RE: SUBMISSION ON THE METROLINK ON BEHALF OF EARLSFORT BASIN LTD, (PREVIOUSLY EARLSFORT VENTURES LTD) IN RELATION TO PROPERTY AT 15-18 EARLSFORT TERRACE, DUBLIN 2

ABP Ref. NA29N.314724

Project Title	Project Metrolink – 15-18 Earlsfort Terrace, Dublin 2	From	Robert Coughlan, PUNCH Consulting Engineers
Project No	222261	To	An Bord Pleanála
Subject	Technical Submission to Railway (Metrolink–Estuary to Charlemont via Dublin Airport) Order 2022 at – 15-18 Earlsfort Terrace, Dublin 2	Cc	
Date	12-01-2023

Figure 20.16 Settlement Contours  
(Hatch St. and Leinster St. Pumping station included)  
Sheet 19 of 28

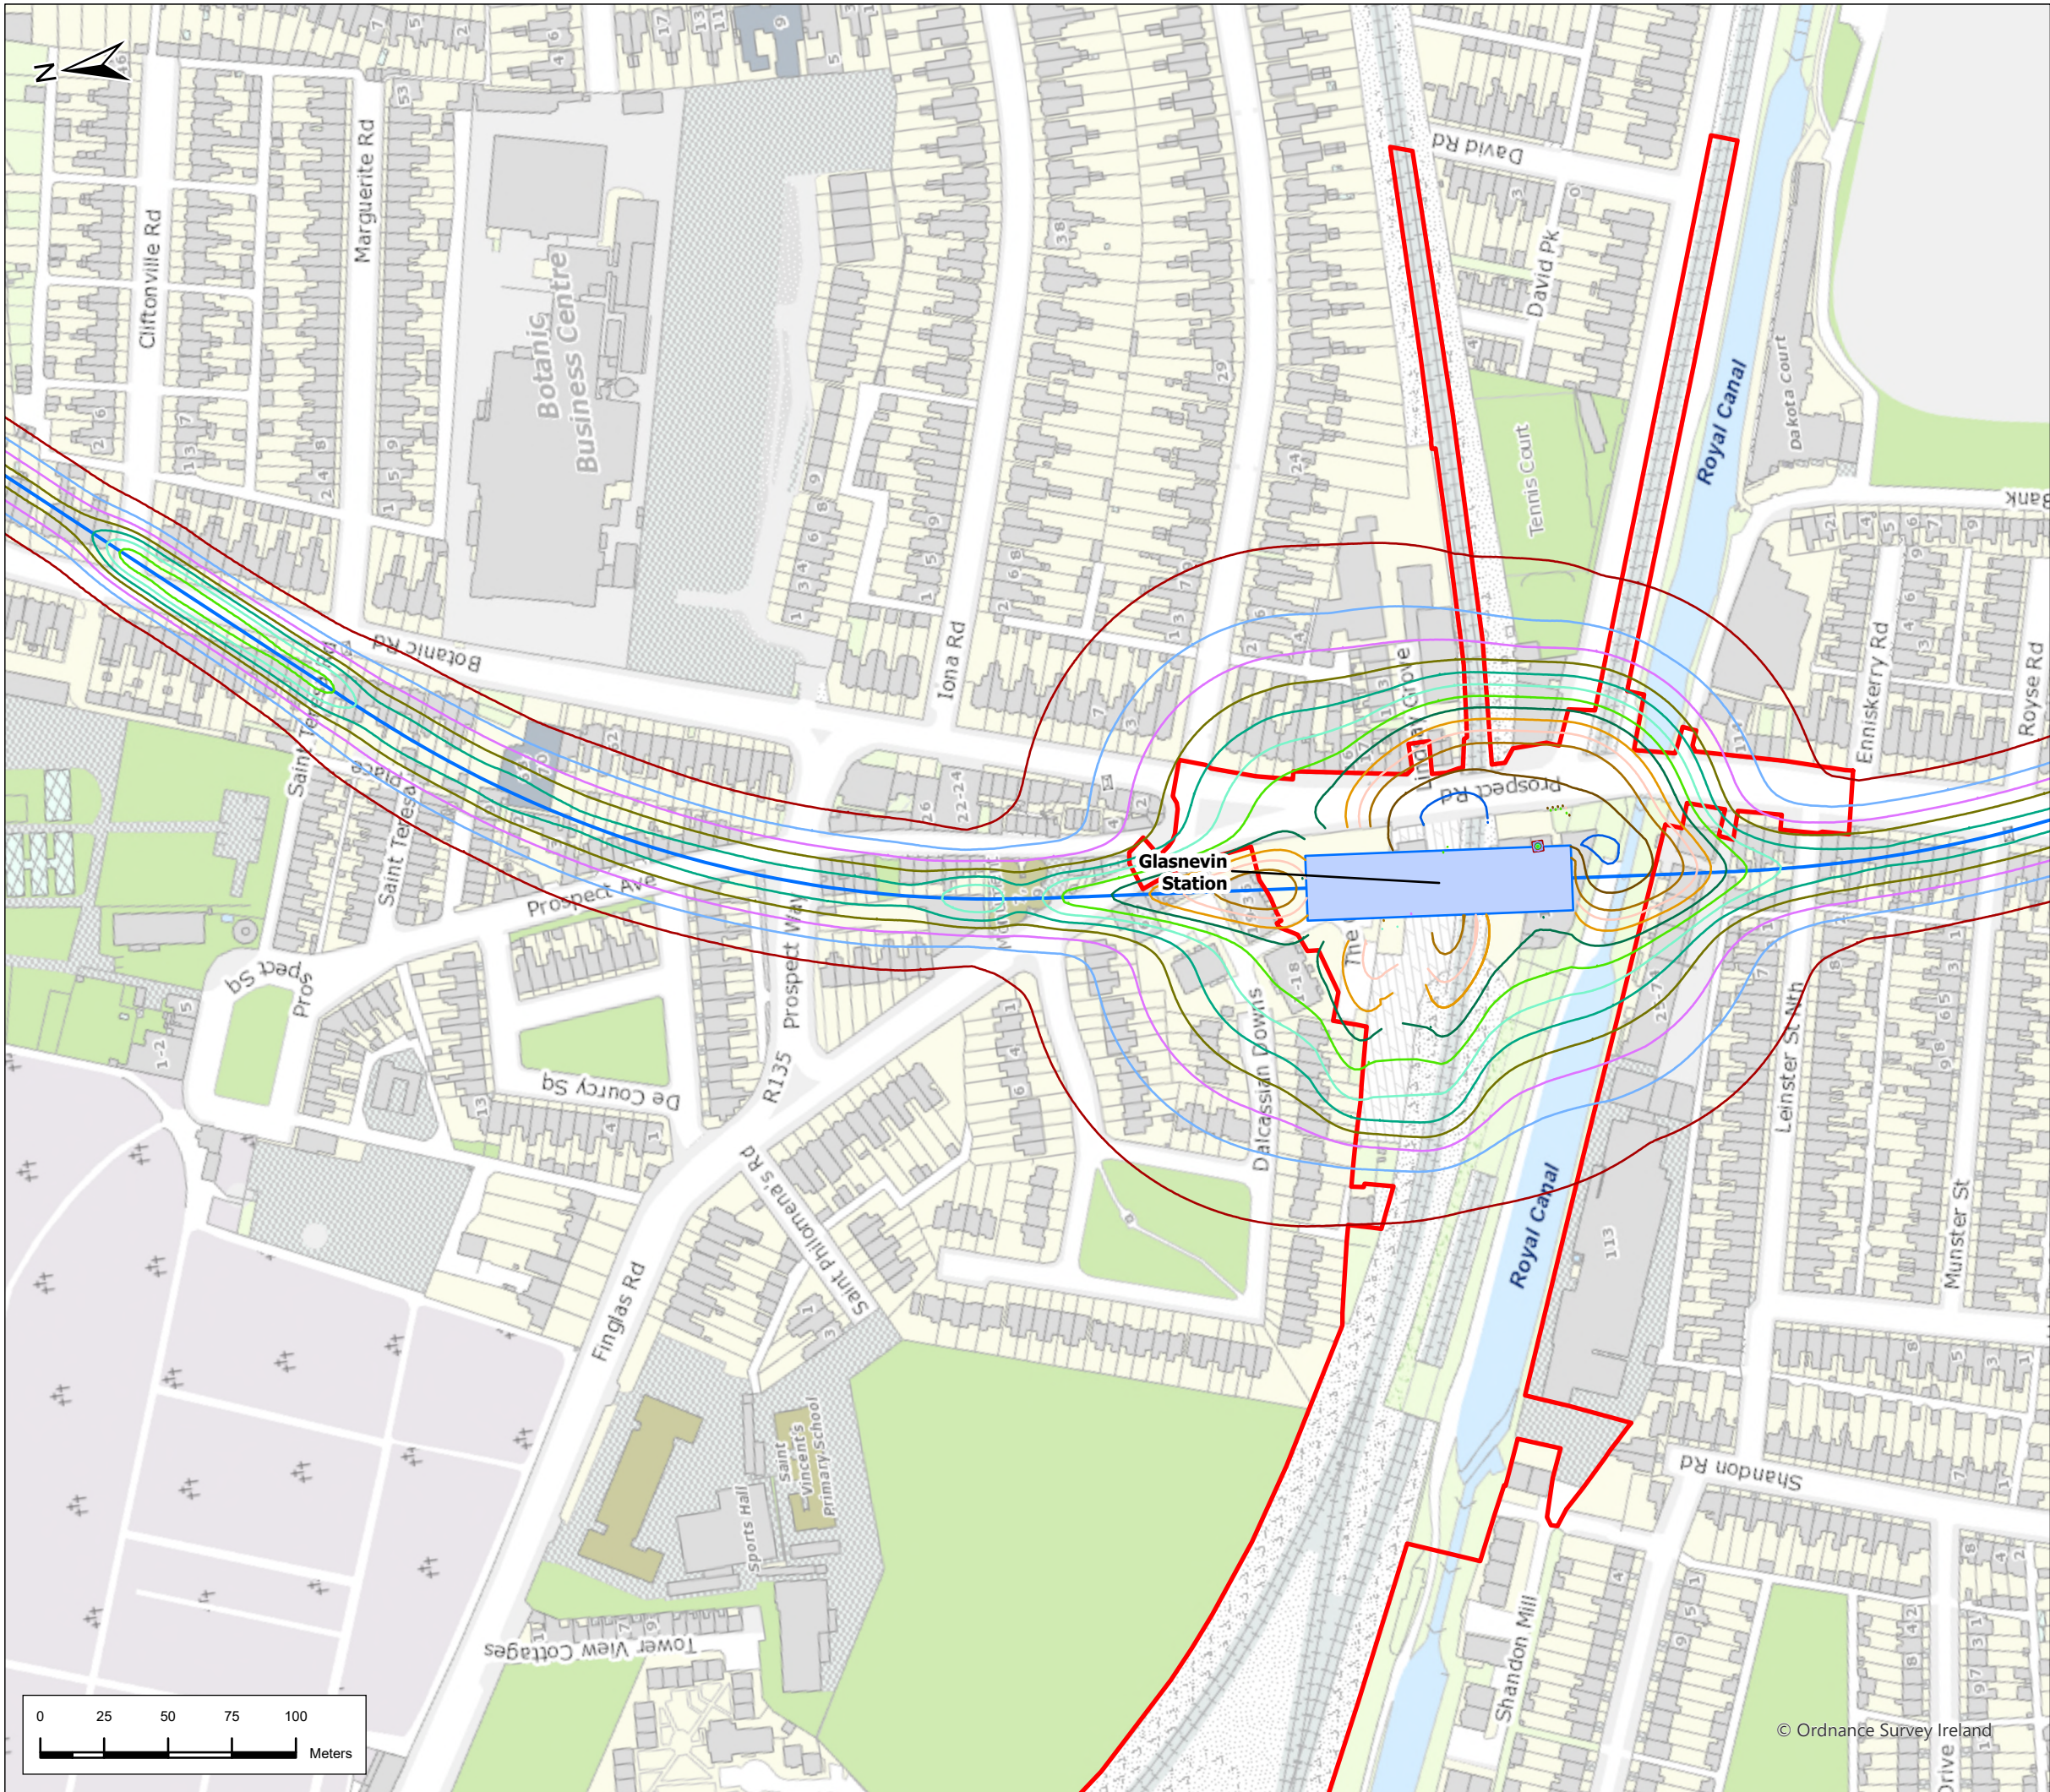
- i) The predicted settlement is a concern from available information on <https://www.metrolinkro.ie/>. The settlement contours on Figure 20.16, sheet 26 of 30 (Refer to Appendix B), suggest settlement up to 25mm in the calculated settlement trough. We request details from TII on how they established this deflection data. The building is a Protected Structure and over 130 years and TII must recognise this.
